19 June 2019

Our Reference: SYD17/00415/08 (A27844958)
Council's Ref: SSD 8707

RESPONSE TO SUBMISSION – NOTICE OF EXHIBITION FOR IVANHOE ESTATE RE-DEVELOPMENT 2-4 LYONS PARK ROAD, MACQUARIE PARK

Figure 3: Herring Road and Ivanhoe Place intersection

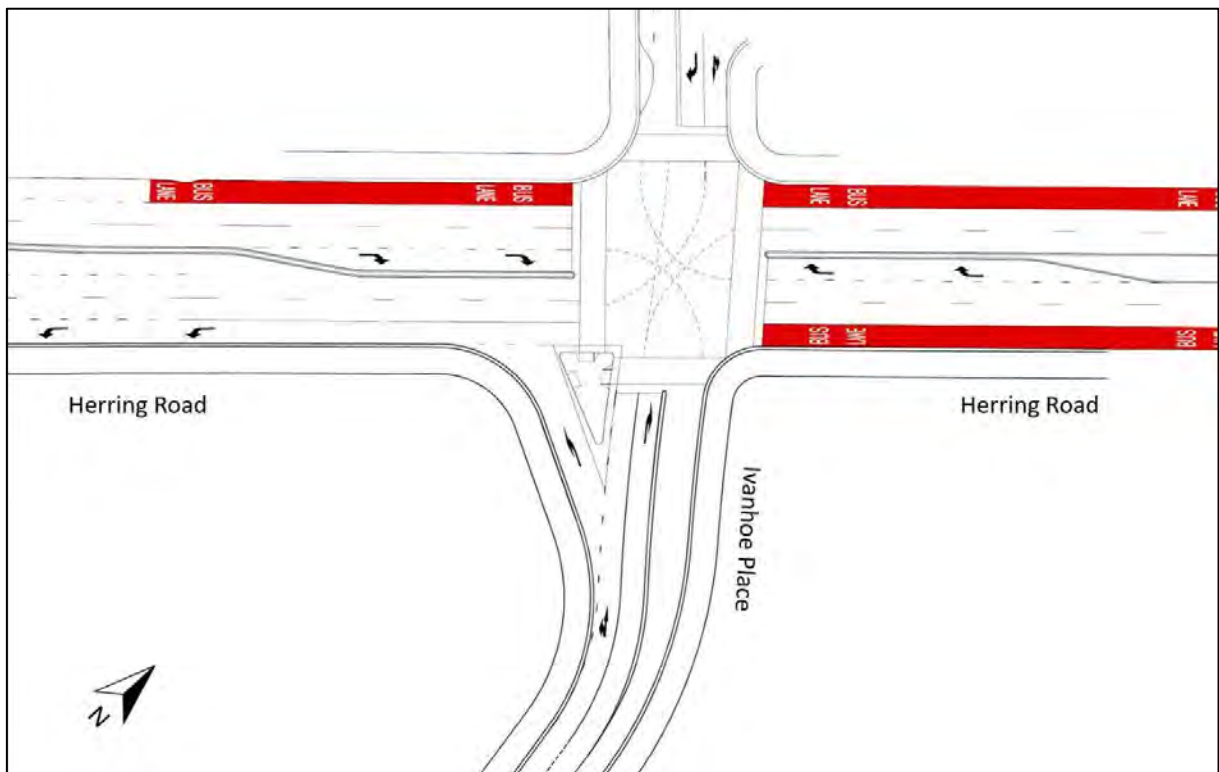
Roads and Maritime will work with proponent (where possible) regarding traffic signal works at Ivanhoe Place & Herring Road intersection with Ivanhoe Estate Road Network development. However, if the intersection is to be signalised prior to the completion of Stage 1 works, then the proponent is to provide a U-turn facility within the site.
